From: Anita Gardner
Sent: 02 October 2013 13:20
To: 'Jason Hales'
Subject: RE: Planning Consultation on: LU/241/13/L

Site Address: Toddington House Toddington Lane Littlehampton BN17 6JX

Description of Works: Application for Listed Building Consent for the demolition of single storey pantry to north elevation and erection of kitchen extension.

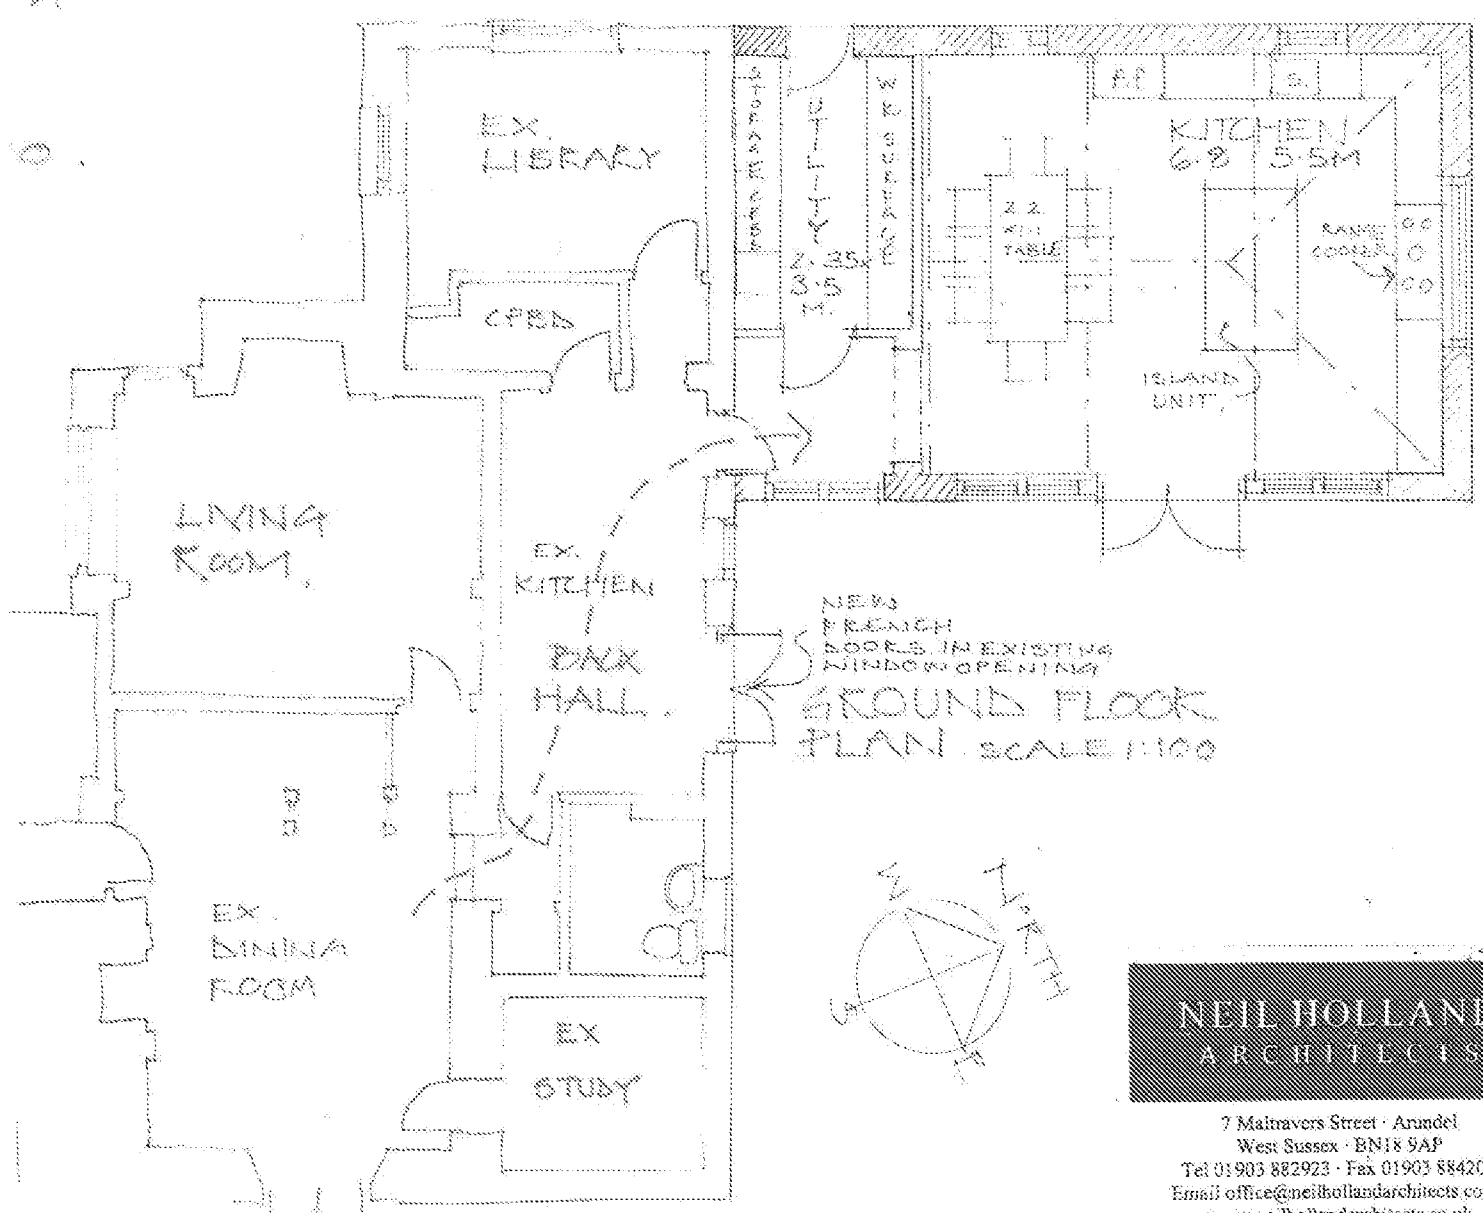
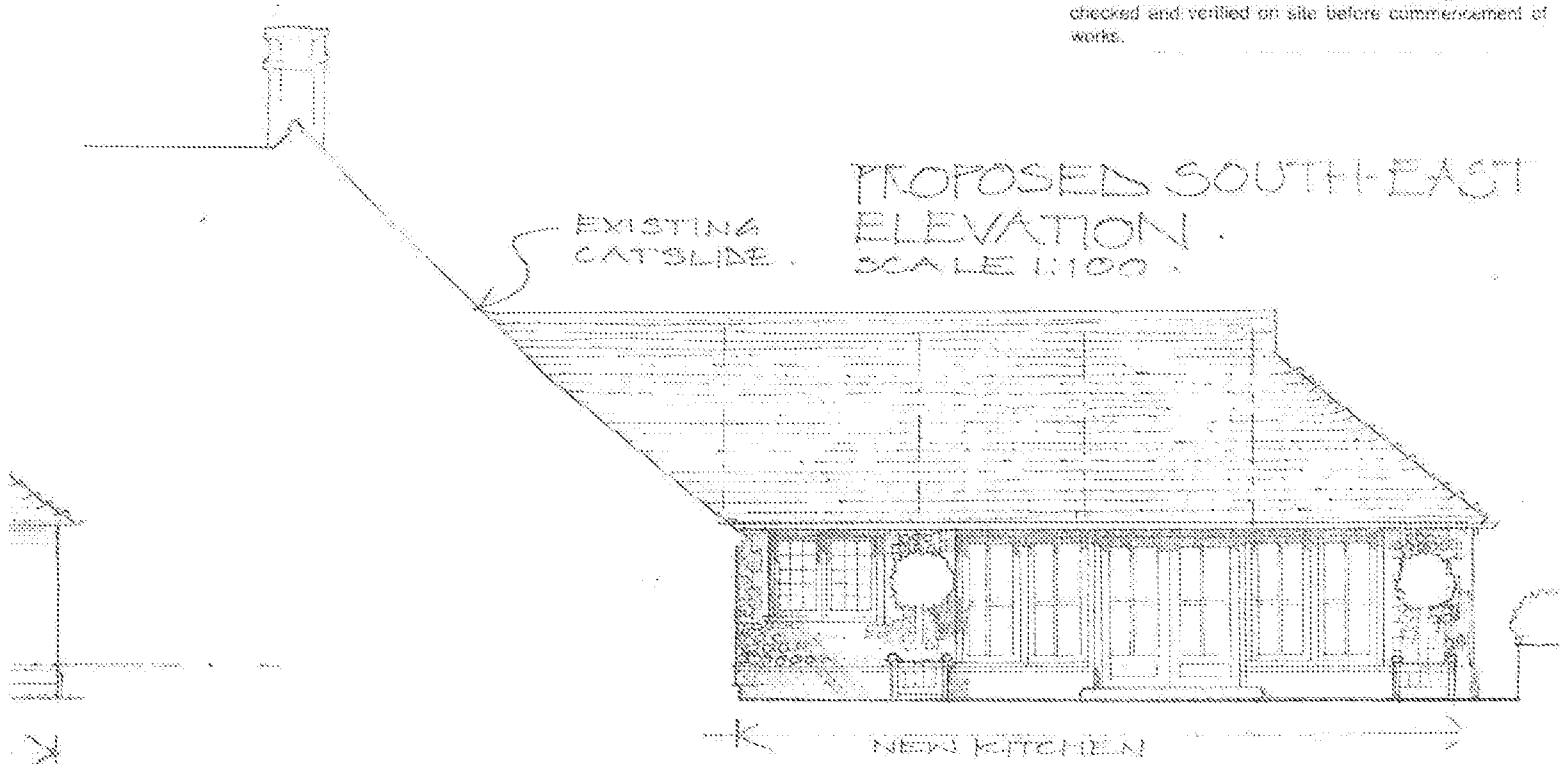
Ian Wightman visits the Council offices on a Wednesday, so he will not be here until next week. I will forward your comments to him, but he will not be in a position to provide a response until the middle of next week. A reduction in the length of the extension in addition to justification is being sought so it is likely your client will need to consider this possibility further.

Accordingly, without prejudice, I would welcome receipt of amended plans reducing the length of the extension by approx. 2.5 metres. It would also be useful if the extract of the proposed ground floor plan could indicate the proposed uses of the ex, dining room, kitchen and library.

I have attached a plan extract with the room names on for ease of reference.

The need for a proper utility room is largely borne out of the fact that the client is loosing an existing, much used large larder and kitchen equipment room store. The space for this can again be hidden away in its own space if housed in the proposed utility room.

During the design process we did look into putting the new utility room in the existing house -- the library and existing kitchen, but these two spaces are too good and important to the existing house design complexity to become the utility for the following reasons:-

The library has rather wonderful panelled walls with bespoke bookcases and complex ceiling structure. Books are a very important element of the home and this room is a wonderful feature of the house. This is highly valued and will continue to be used as the library and music room. This makes the library an unsuitable option.

The existing kitchen space is to become the back hall and is the only thorough-fare through the main house to the new kitchen extension. Making this space into a Utility Room would be an unfeasible and impractically designed feature and would compromise the current, composite design features of the house and therefore would be unacceptable; the client understandably did not wish to fill it with utility units.

Rooms such as the second bedroom are already being used as other rooms for ironing etc and combined with the above reasons, we believed this substantiated the need to position the new utility in the new extension out of the existing house.
